Crumhach Wind Farm, Co. Sligo

Stage 1 Road Safety Audit

Alan Lipscombe Traffic and Transport Consultants

August 2026

Site Access B - L2702

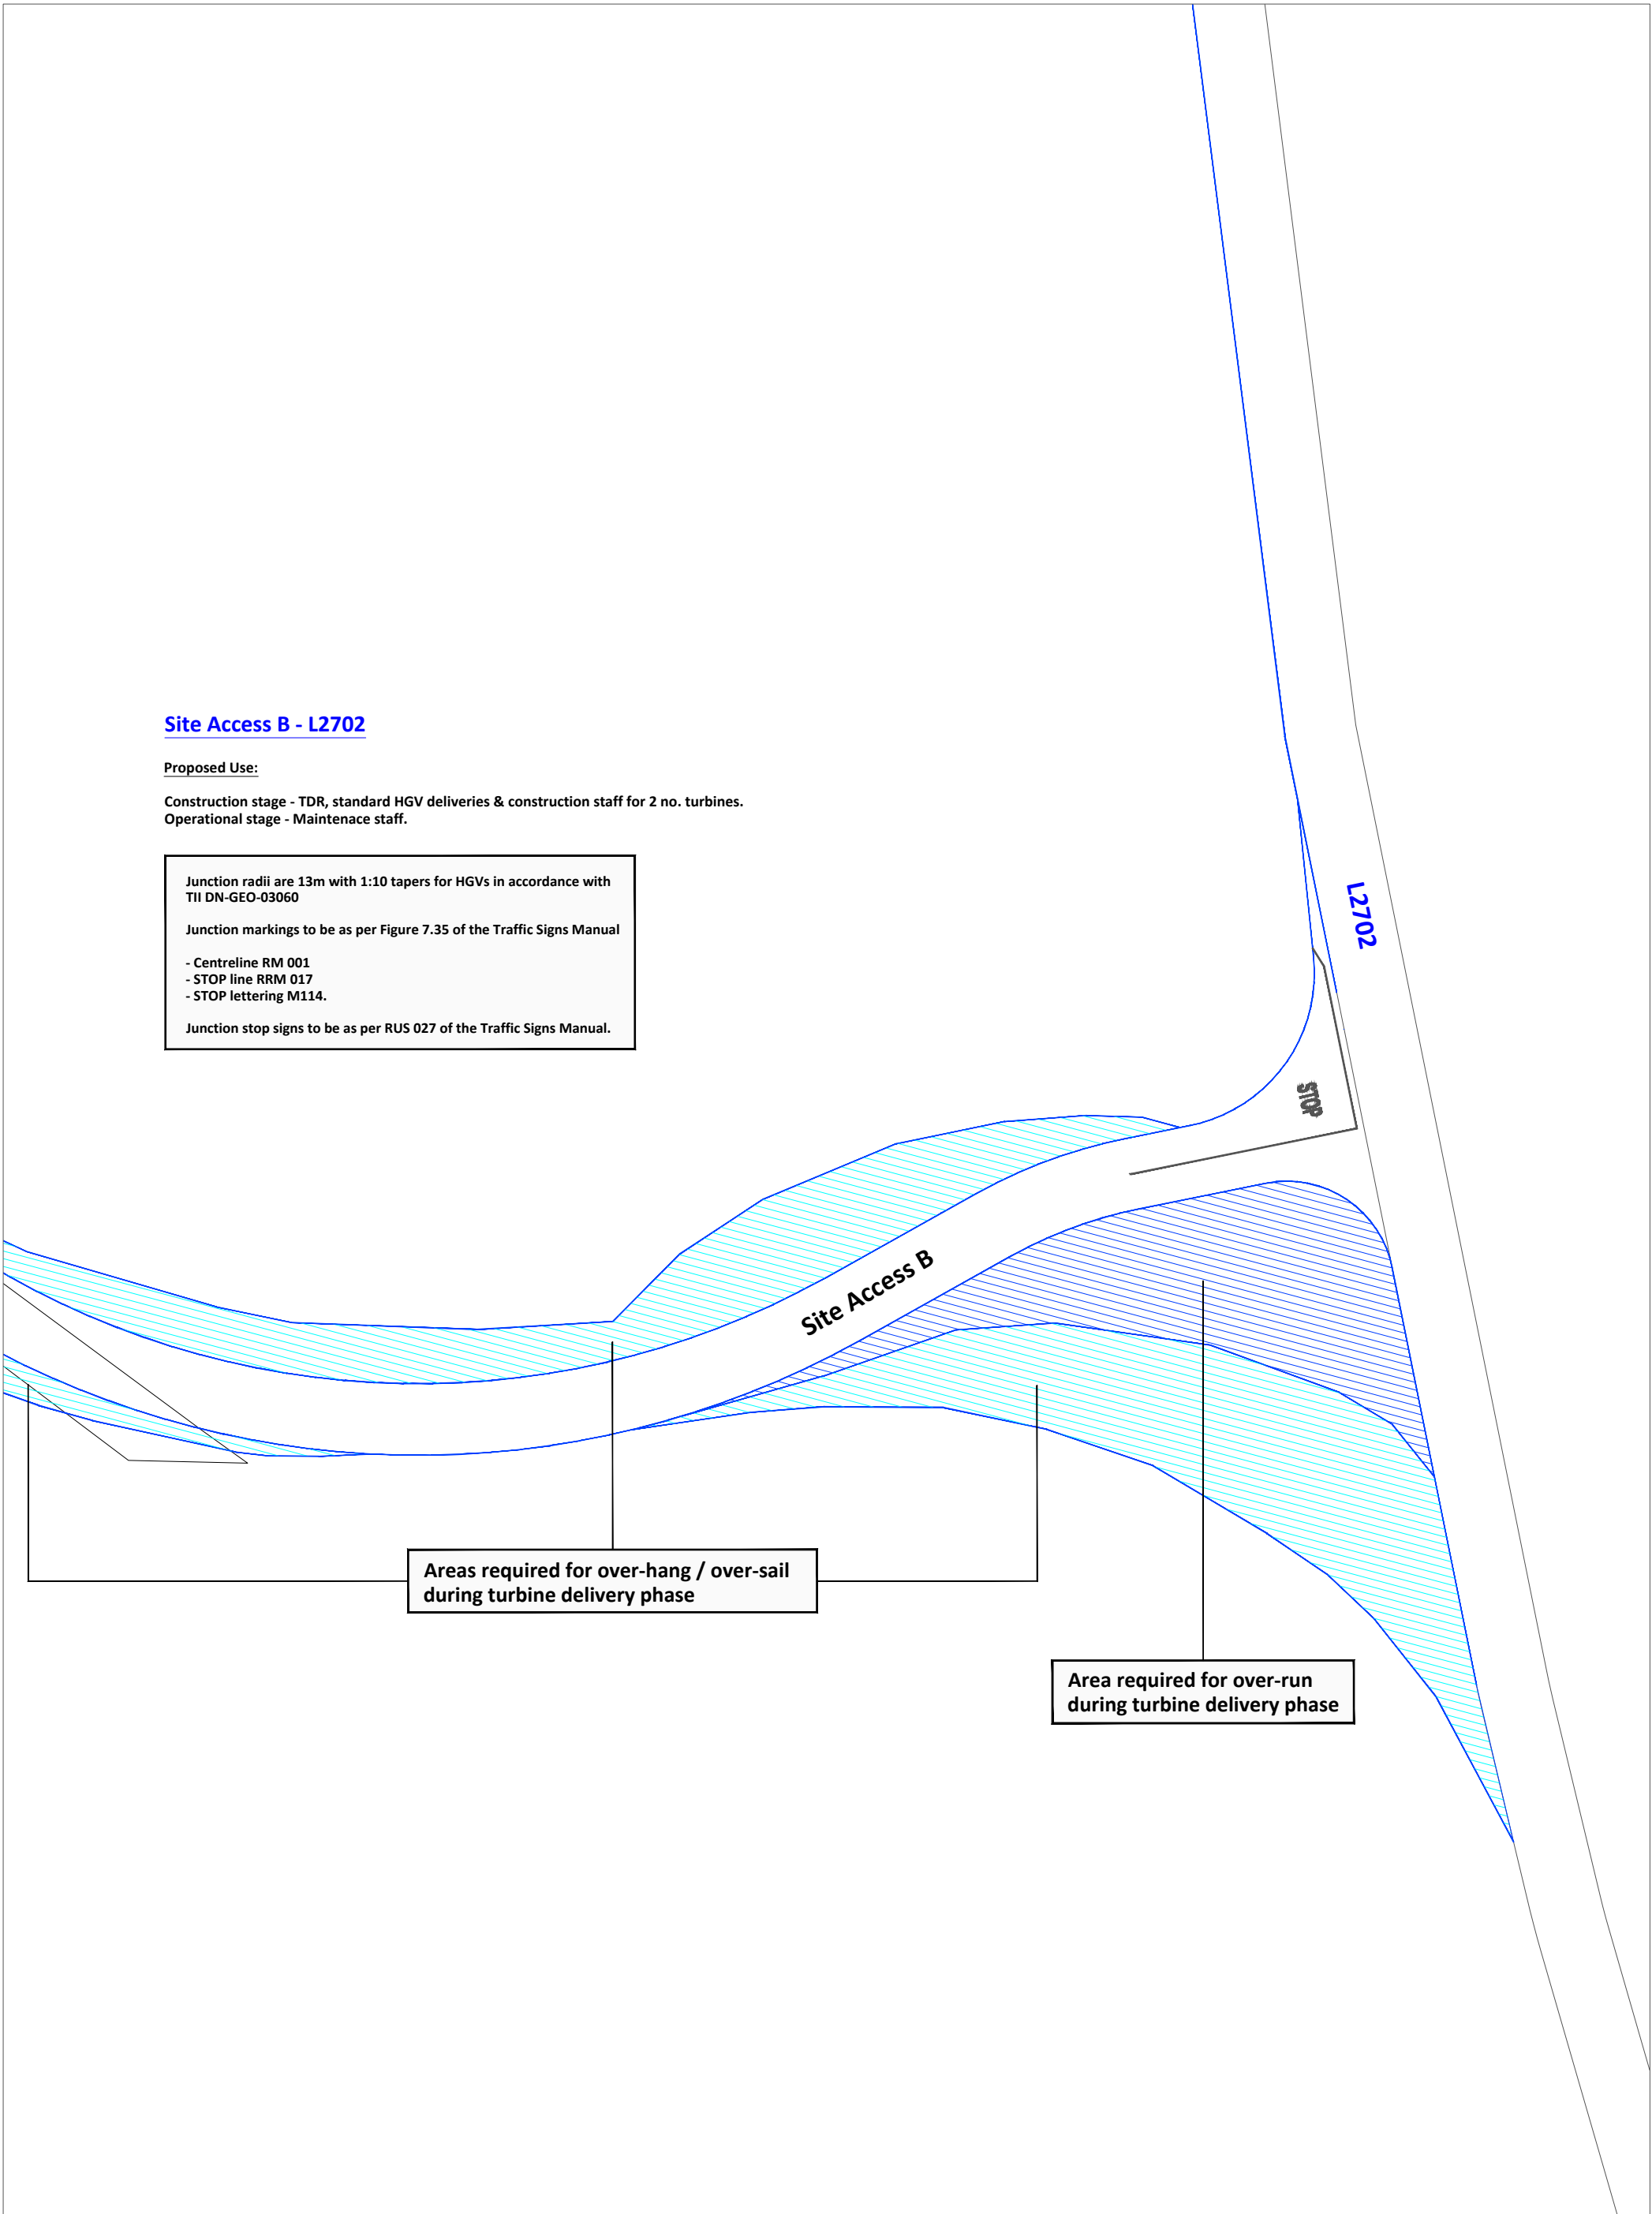
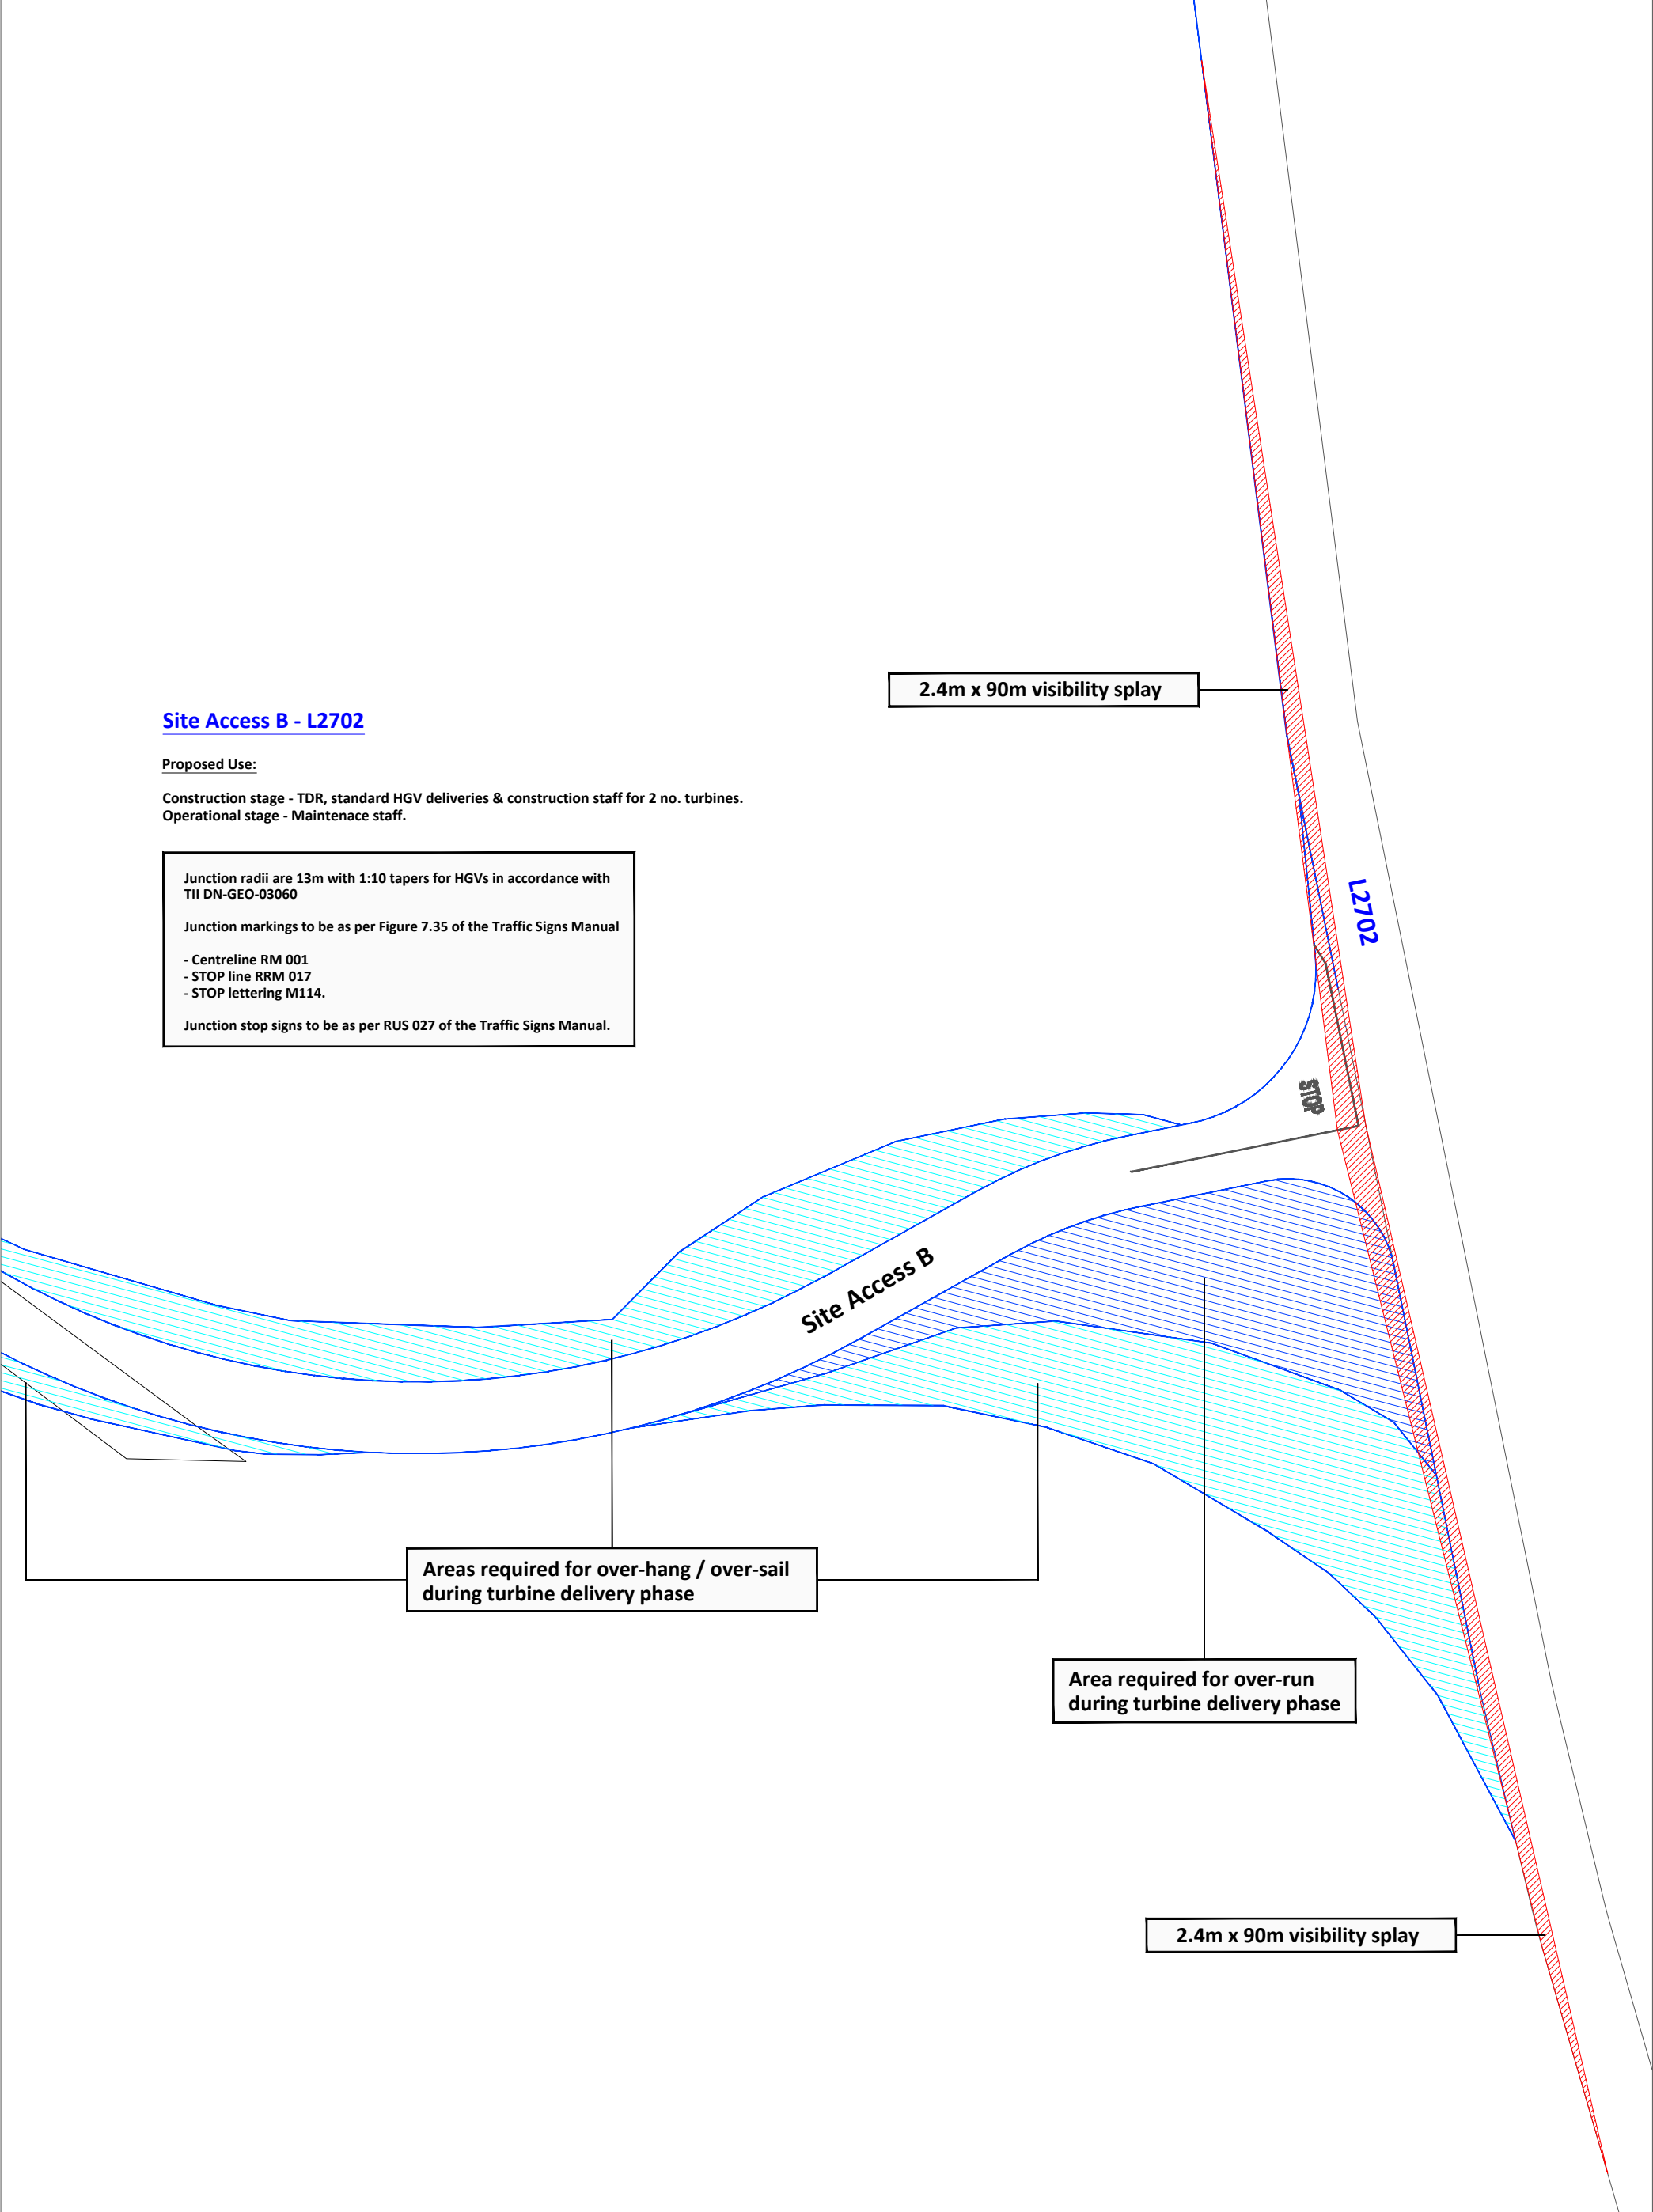
2.2 Problem: Drivers Confused by Redundant Access Track

Location: Site Access B – Local Road L2702, Existing Access Track to South

The existing section of access track (made redundant by Site Access B) might create confusion for drivers who could enter it by mistake, leading to sudden braking, loss of control or conflicts with construction traffic.

Recommendation

The section of redundant access track should be removed.

2.1	Access A For Record Purposes Only. No Safety Issues Identified.			
2.2	Yes	No	It is proposed that the existing access will be retained for local access only and managed during the construction phase. It is proposed that both accesses are gated with the opening of each access managed on site during the construction phase. On the completion of construction the over-run areas will be closed off permanently. Appropriate signage will be put in place at both the existing and proposed new access tracks to clearly distinguish the existing access for local landowners from construction and operational access to the Proposed Wind Farm.	Yes
